Subject: **Request for Permit Modification** for TIP No. U-2404 A, Catawba
County, Newton/Conover Loop; State Project No. 8.1792401; Federal Aid
Project No. MA-STP-16(2), Division 12.

Reference: Individual Permit, USACE Action ID No. 200331233, issued on
December 4, 2003. Major Certification, DWQ Project No. 031048, issued
on October 8, 2003.

The U.S. Army Corps of Engineers (USACE) issued a Section 404 Individual Permit (IP) to the North Carolina Department of Transportation (NCDOT) on December 4, 2003 for construction of the Newton-Conover Eastern Loop, from NC Highway 16 north to SR 1739 (Emanuel Church Road) east of Newton, Catawba County. The purpose of this letter is to request a modification of Permit Site Nos. 1, 3, & 5.

MATCH LINE -Y2- STA. 11+40 SHEET 23

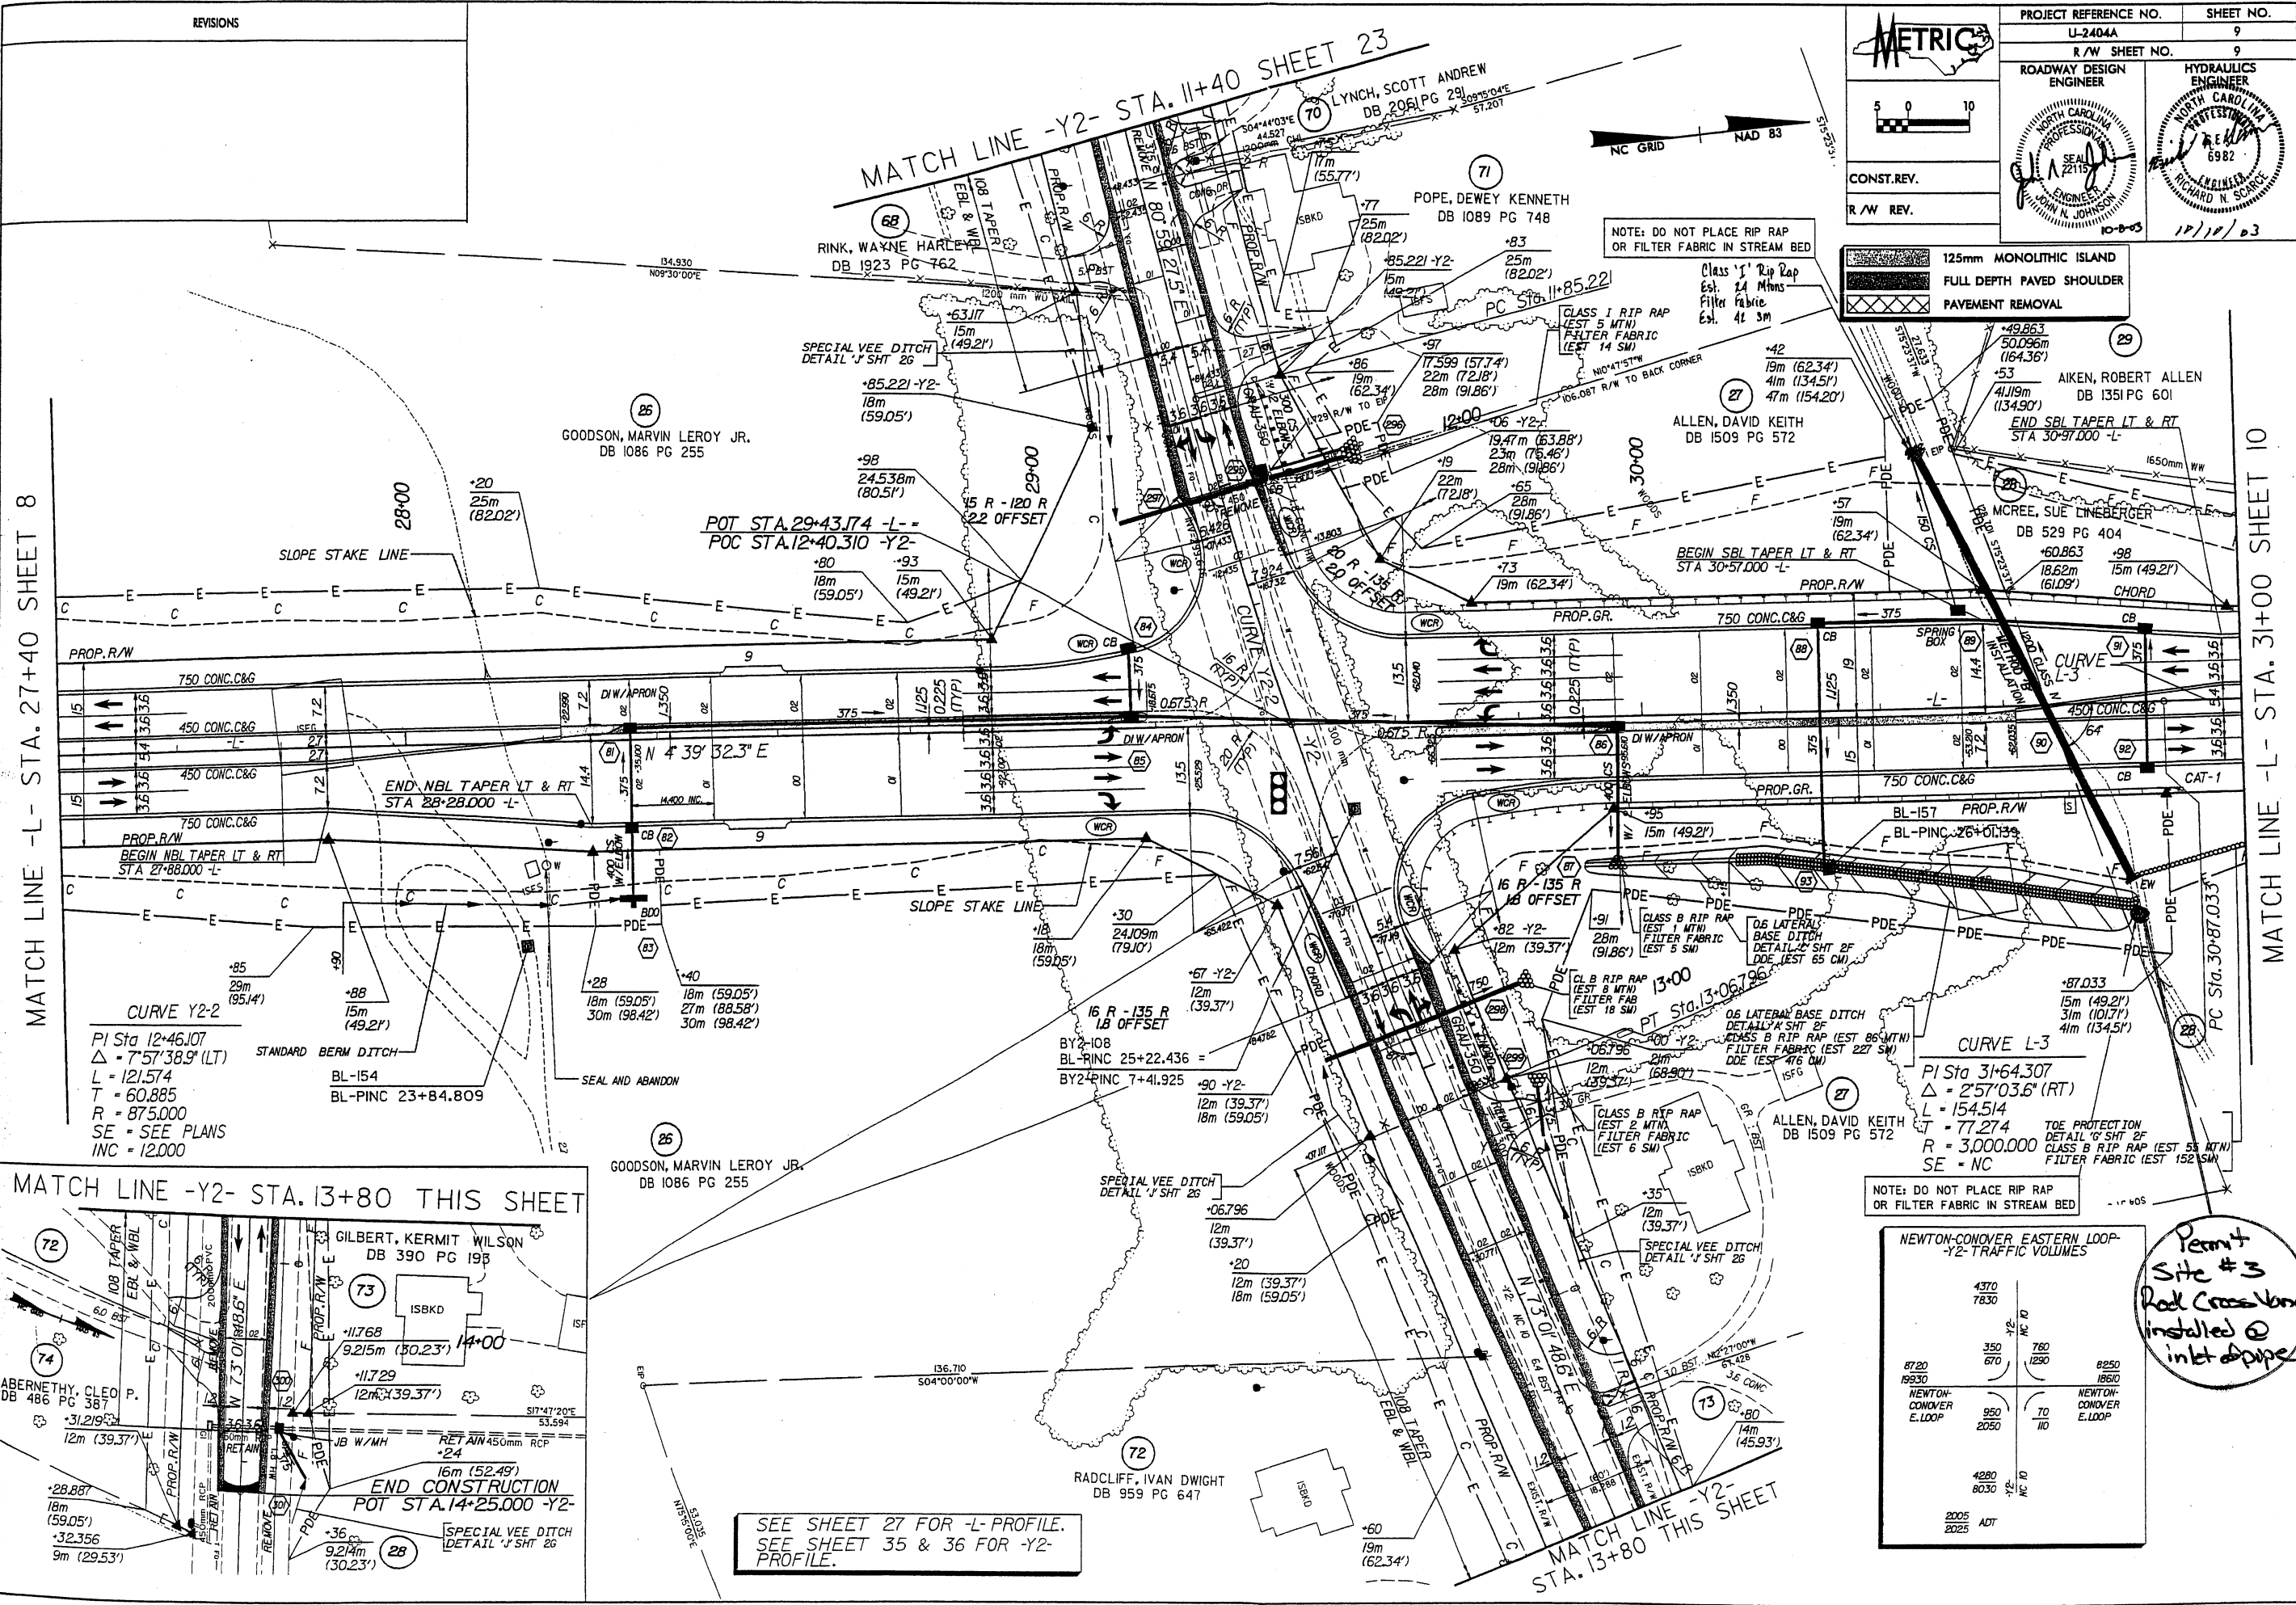
During a 401 Permit Compliance Inspection conducted by DWQ on December 13 & 17, 2004, it was requested that rock cross vanes be installed at Permit Site Nos. 1 & 3. The cross vanes are to be used for grade control to stop head cutting.

At Permit Site No. 3 rip-rap has fallen into the stream from the adjacent rip-rap lined ditch located at the inlet end of the culvert. Also, the bank of the stream has sloughed off and deposited sediment into the stream. As a result, there is a large head-cut forming upstream. We plan to remove the rip-rap and sediment from the stream, stabilize the sloughed bank, and install a cross vane to prevent further damage.
